**Brown & Root**  
 16610 Dallas Parkway, Suite 2200 / Dallas, TX 75248  
 December 18, 1998  
 LETTER NO.: HBZ 260-552  
 SUBJECT FILE CODE: 765.10  
 H. B. Zachry Company  
 PO Box 1004  
 Addison, Texas 75001-1004  
 REF: Addison Airport Toll Tunnel  
 DNT-260  
 Attention: Mr. James Gardner  
 SUBJECT: Underdrain along Southeast "Shotcrete" Retaining Wall (RFI-194, EAR-26)

**H. B. ZACHRY COMPANY**  
**REQUEST FOR INFORMATION**  
**ADDISON AIRPORT TUNNEL**  
 Subcontractor (if applicable): N/A  
 Originator: Majed Luman  
 Reply Req'd By: ASAP  
 Distribution List: Bill Leach, George James  
 Problem: Rock bolts in east portal of tunnel  
 Possible rework or extra work involved with this RFI?  N  Y  
 Delays in project execution involved with this RFI?  N  Y  
 Estimate of time spent evaluating, finding alternate solution to RFI? Engineering: 0 Hrs, Surveying Crew: 0 Hrs, Other: 0 Hrs  
 Proposed Solution by Contractor By: [Blank] Date: [Blank] Reviewed By: [Blank]  
 Response by Construction Management: [Blank]

NO.	REVISION	BY	DATE
NORTH TEXAS TOLLWAY AUTHORITY ADDISON AIRPORT TUNNEL			
RFI# 194 - 201			
DRAWN _____ DATE _____		DESIGNED _____ DATE _____	
CHECKED _____ DATE __

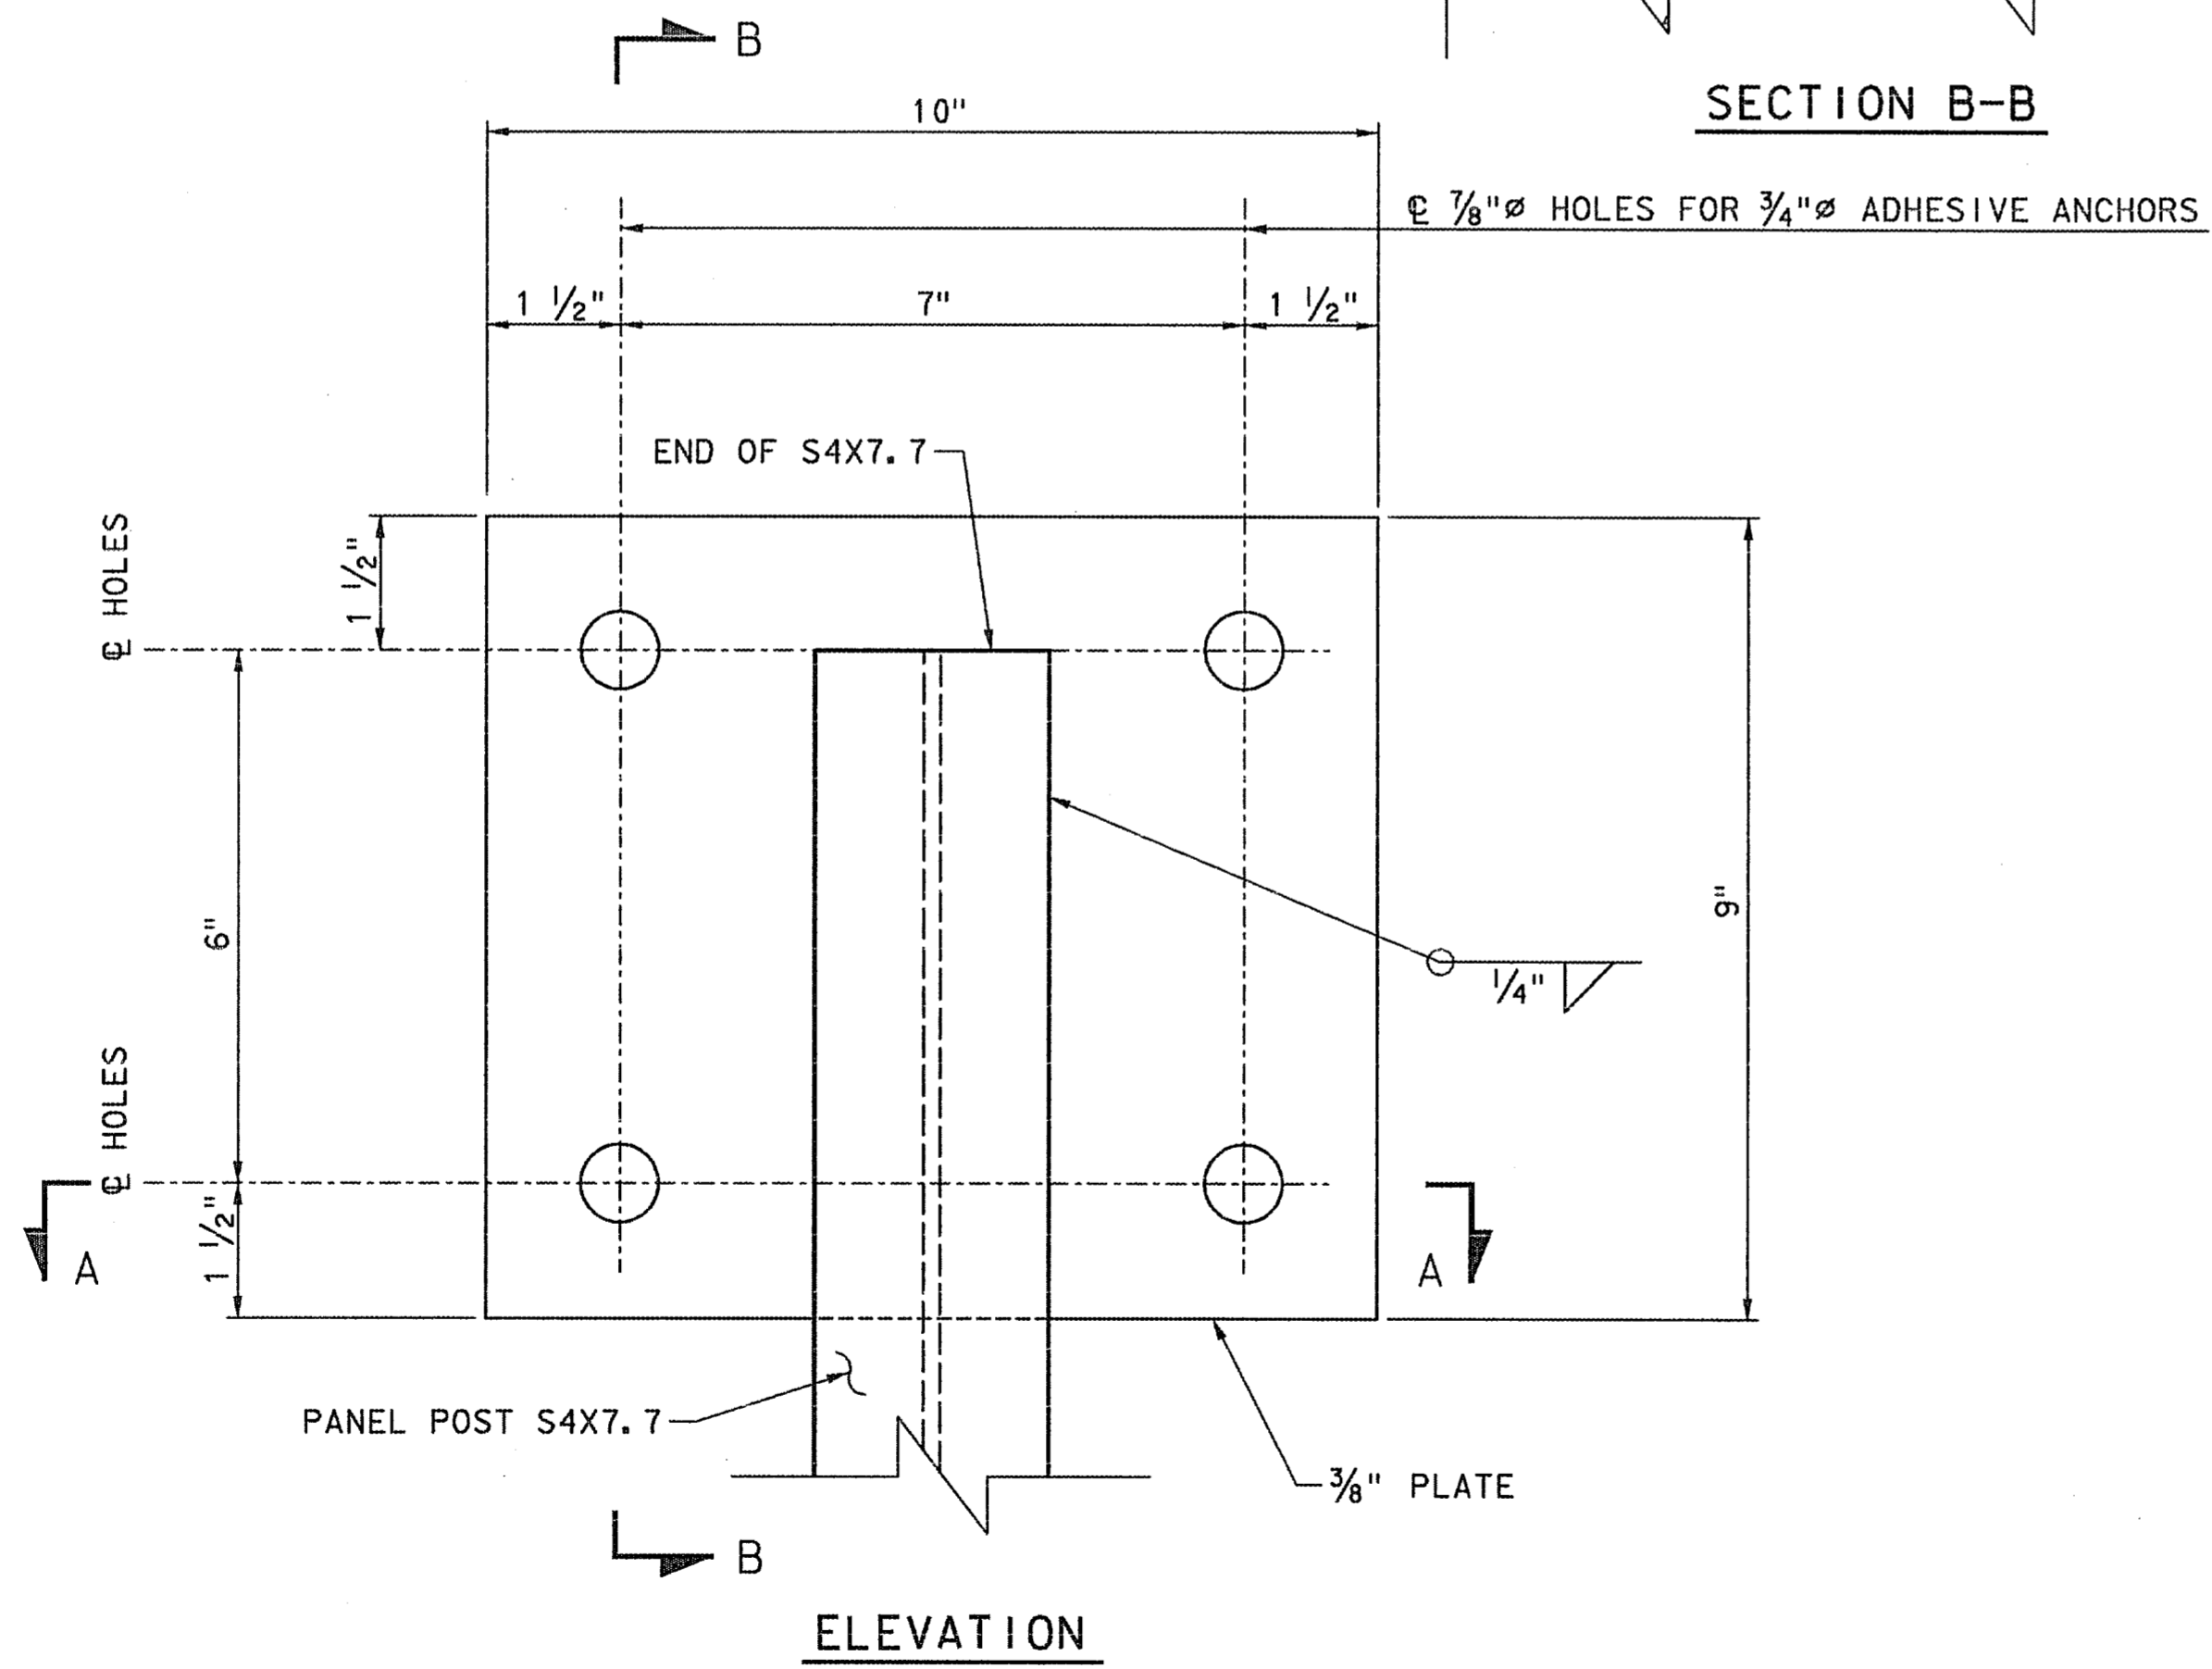
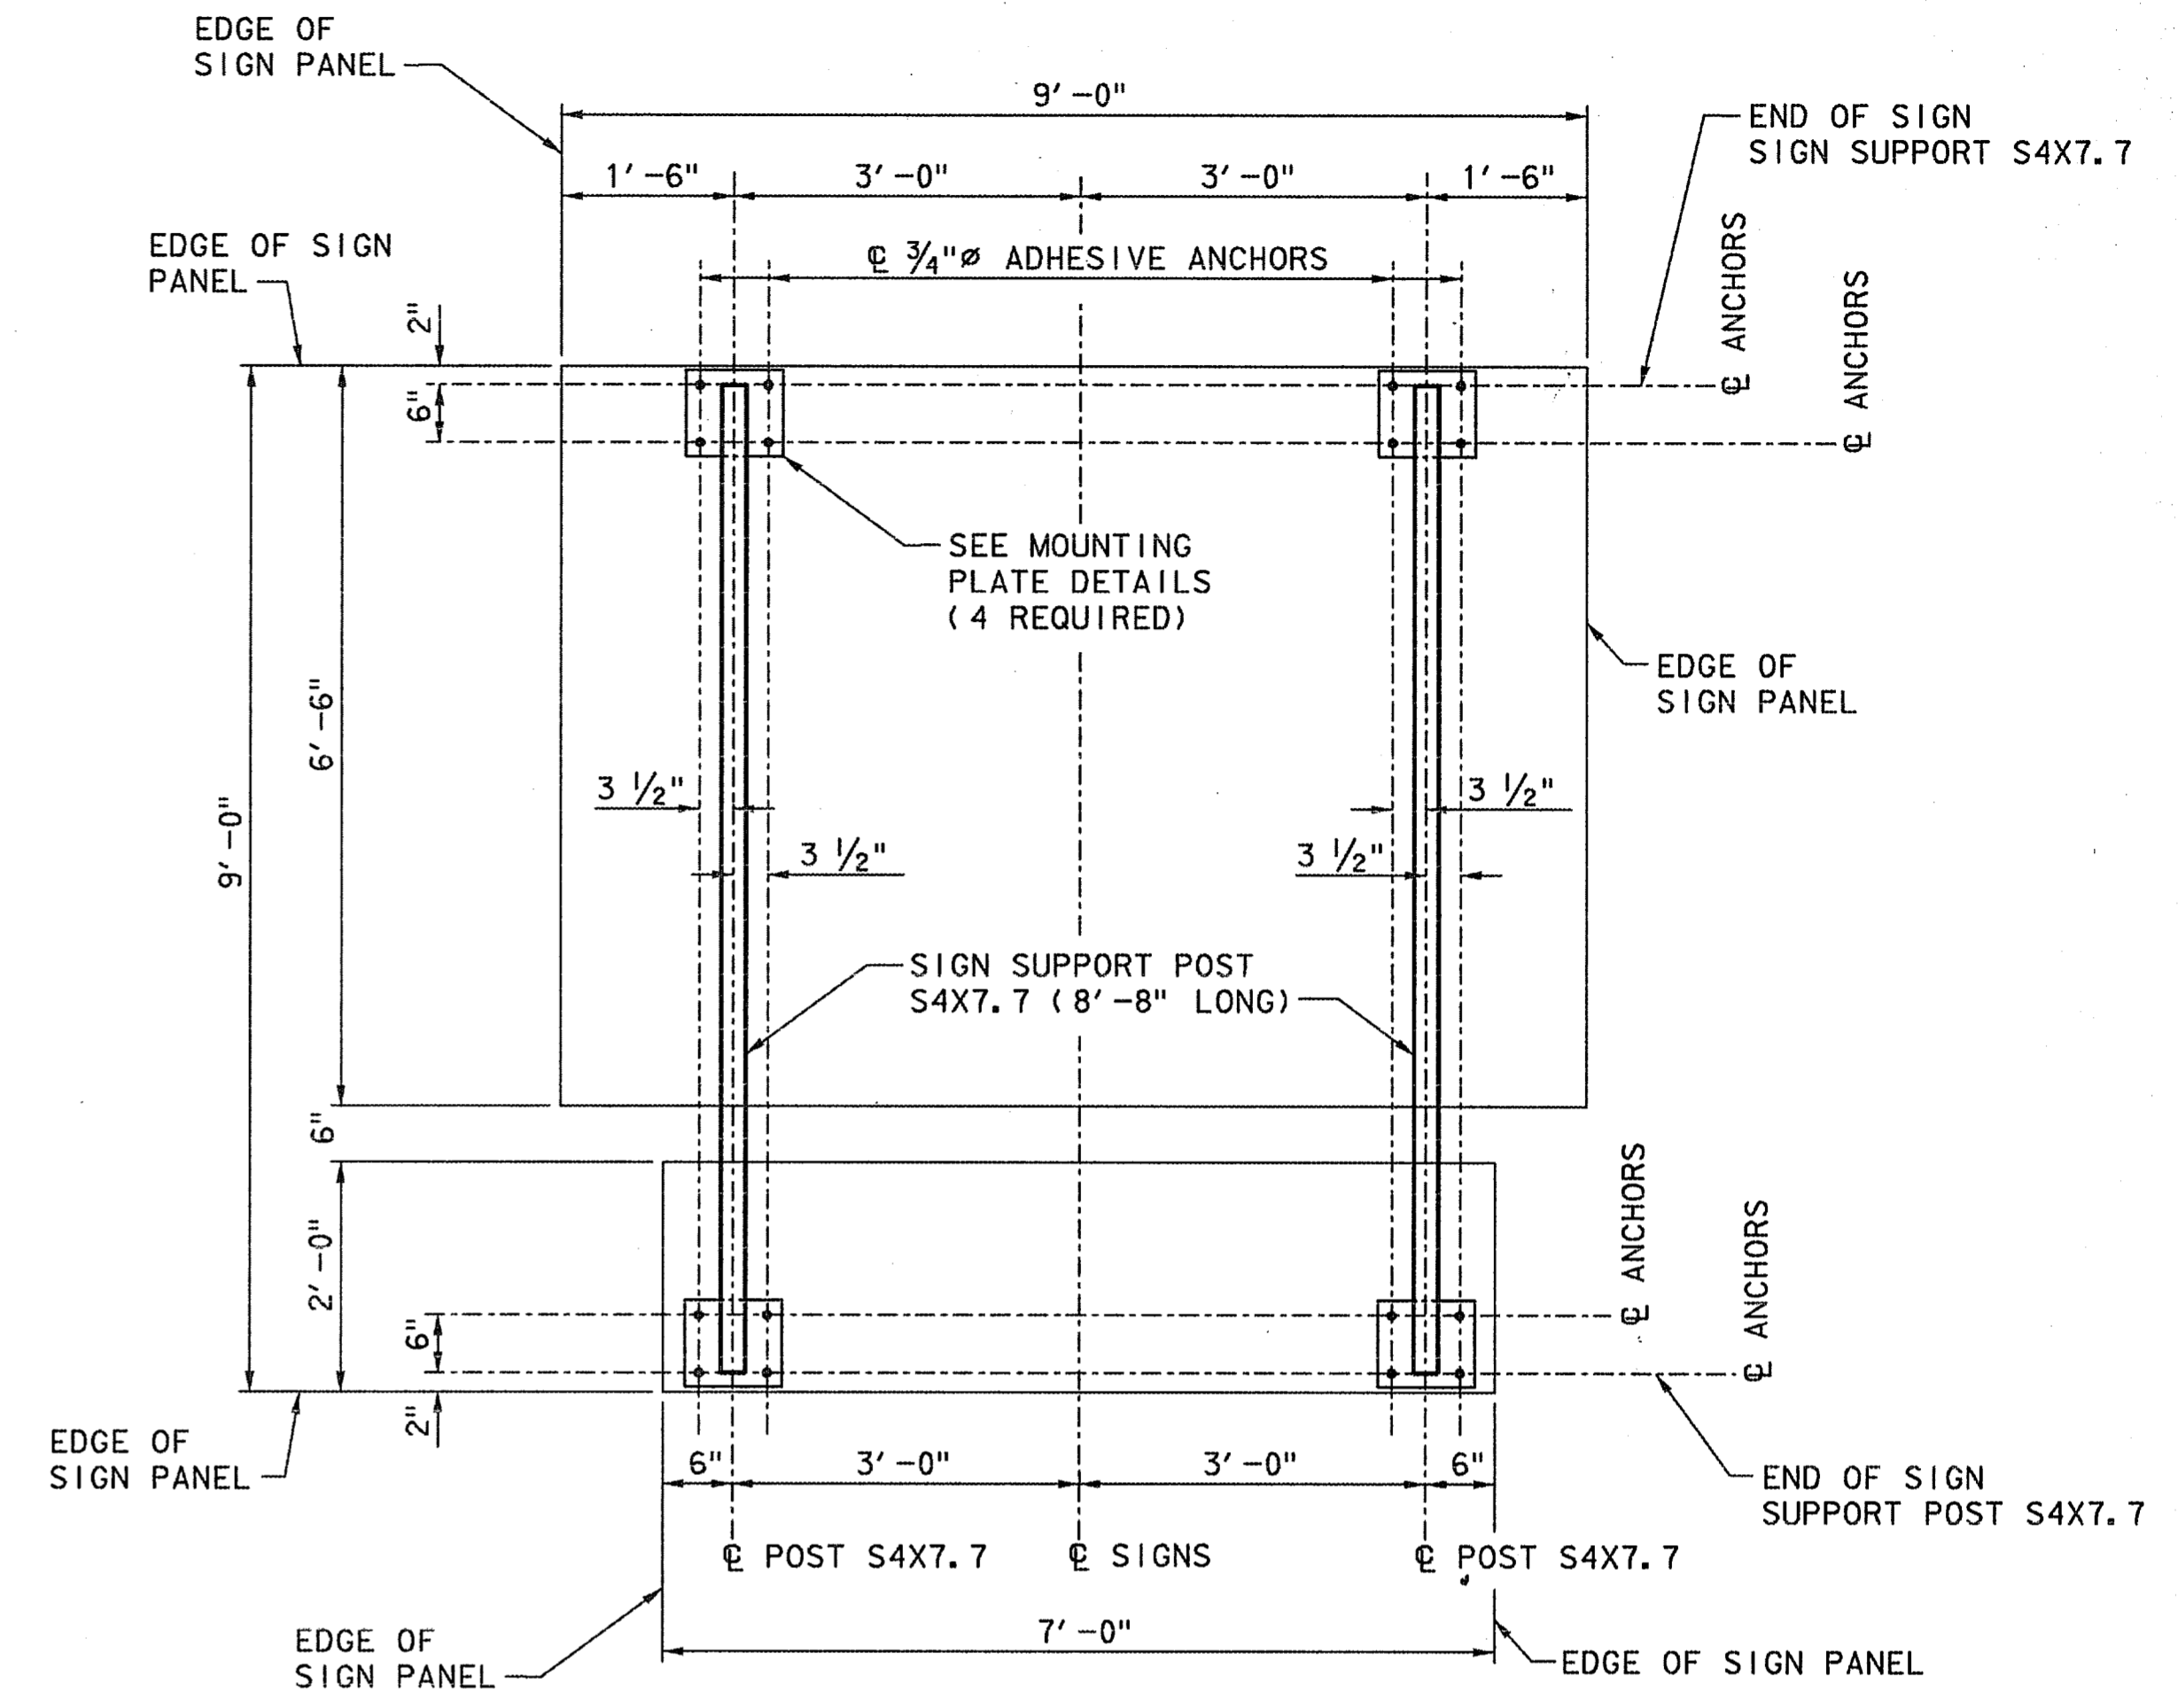
**ZACHRY CONSTRUCTION CORP.**  
**REQUEST FOR INFORMATION**  
**ADDISON AIRPORT TUNNEL**  
 Subcontractor (if applicable): S&J Electrical  
 Originator: Zachry Const. Corp.  
 Reply Req'd By: S&J Electrical  
 Distribution List: Bill Leach, Majed Luman  
 Problem: Overhead Sign #1 and #2  
 Possible rework or extra work involved with this RFI?  N  Y  
 Delays in project execution involved with this RFI?  N  Y  
 Estimate of time spent evaluating, finding alternate solution to RFI? Engineering: 1 Hrs, Surveying Crew: 1 Hrs, Other: 0 Hrs  
 Proposed Solution by Contractor By: HB Zachry Co. Date: 01/2/99 Reviewed By: J. Gardner  
 Response by Construction Management: [Blank]
